CITY OF ALBUQUERQUE

March 23, 2022

RE: 4000 Ellison NE
4000 Ellison Street NE
Grading and Drainage Plan
Engineer's Stamp Date: 1/17/22
Hydrology File: D17D074

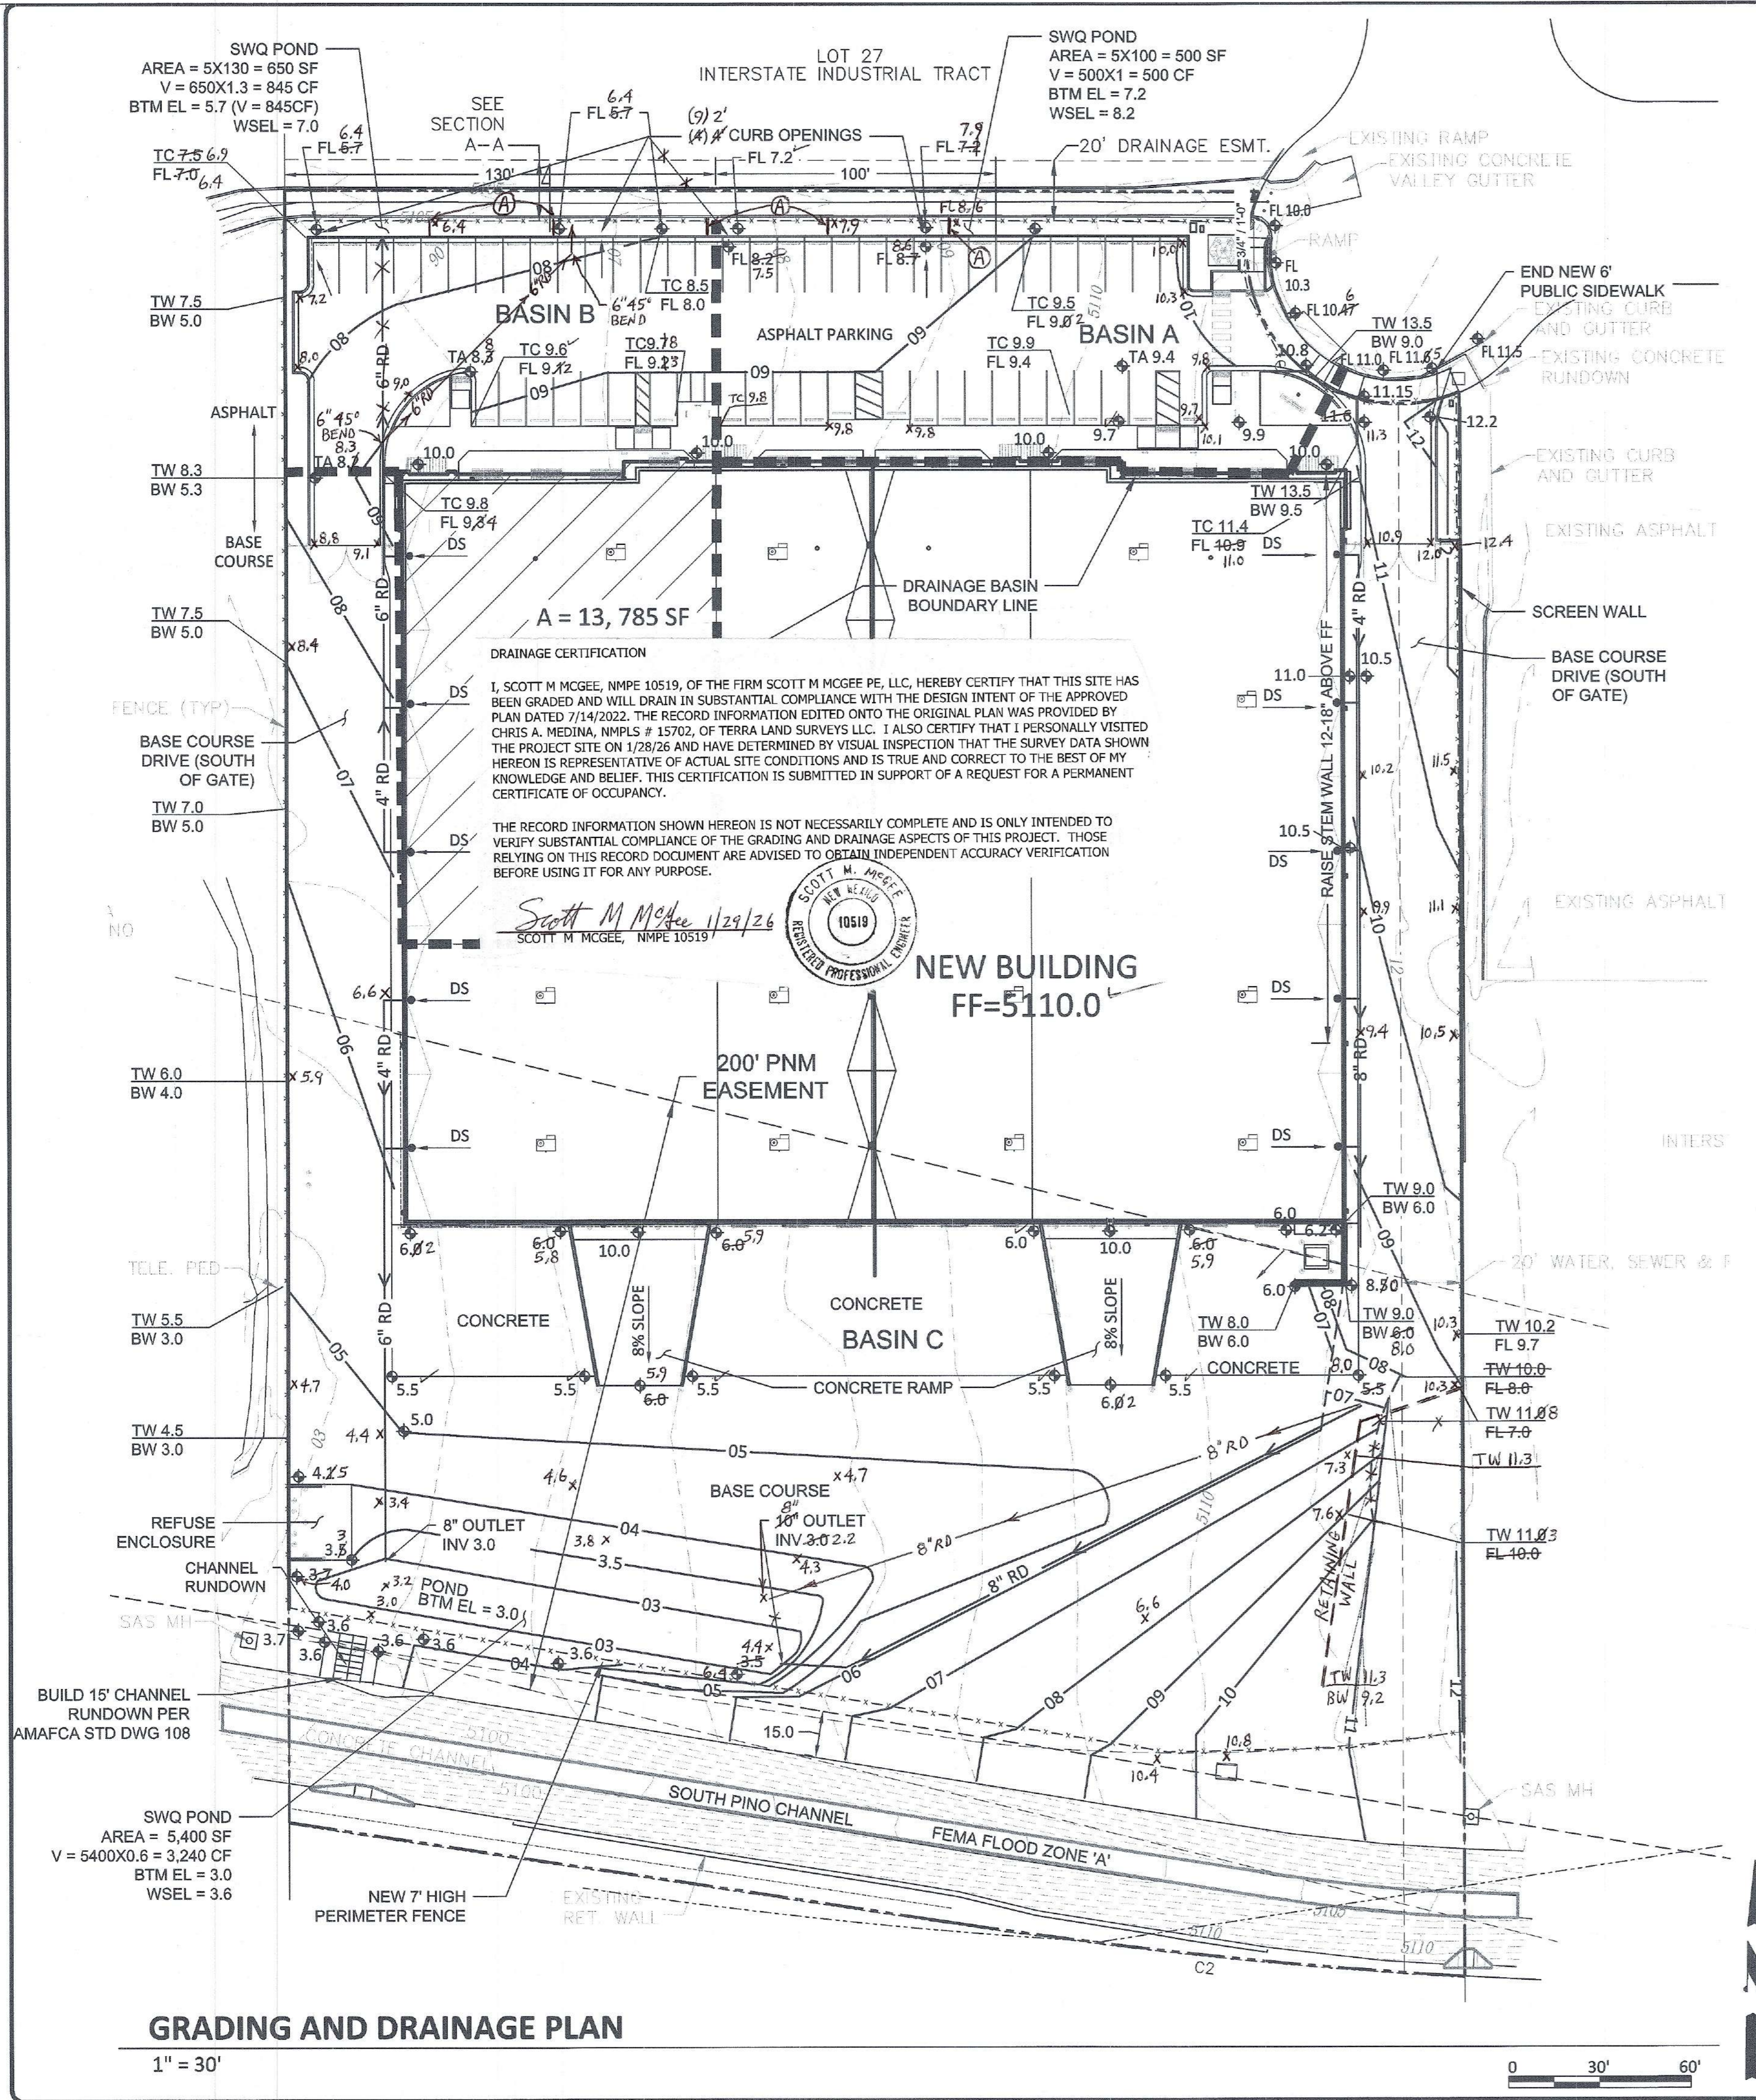
1. Please provide survey points.
2. Provide a detail of the retention pond and clearly show a defined area for these. Determine if fencing is needed around the pond.
 - a. Will there be a barrier for the pond at the South Pino Channel?
 - b. This site will require AMAFCA review for their input.
3. Is PNM okay with constructing a structure etc... within the shown easement?
 - a. Please call out the document number and filing date. For both Easements and note are they existing or proposed?
4. What is this? (Trash enclosure)

- a. Please identify a basin delineation.
7. I see a call out for a CMU wall but it is not clear what line on the plans the leader points to. Please include this in the legend and make it clear to see on the plans.

- a. Please provide background calculations.
9. For each basin, please explain how much flow/volume are included and where it goes to also ensure each pond can handle the flow/volume.
10. Inlets into the pond should be analyzed to ensure the flow gets there adequately (weir calculations).
11. Clearly highlight ponds so they are easy to identify the boundary. Especially the one on the NW side of the site. It is not apparent what the limits of this pond are. I can see two points near each other that can be telling but it is not clear.
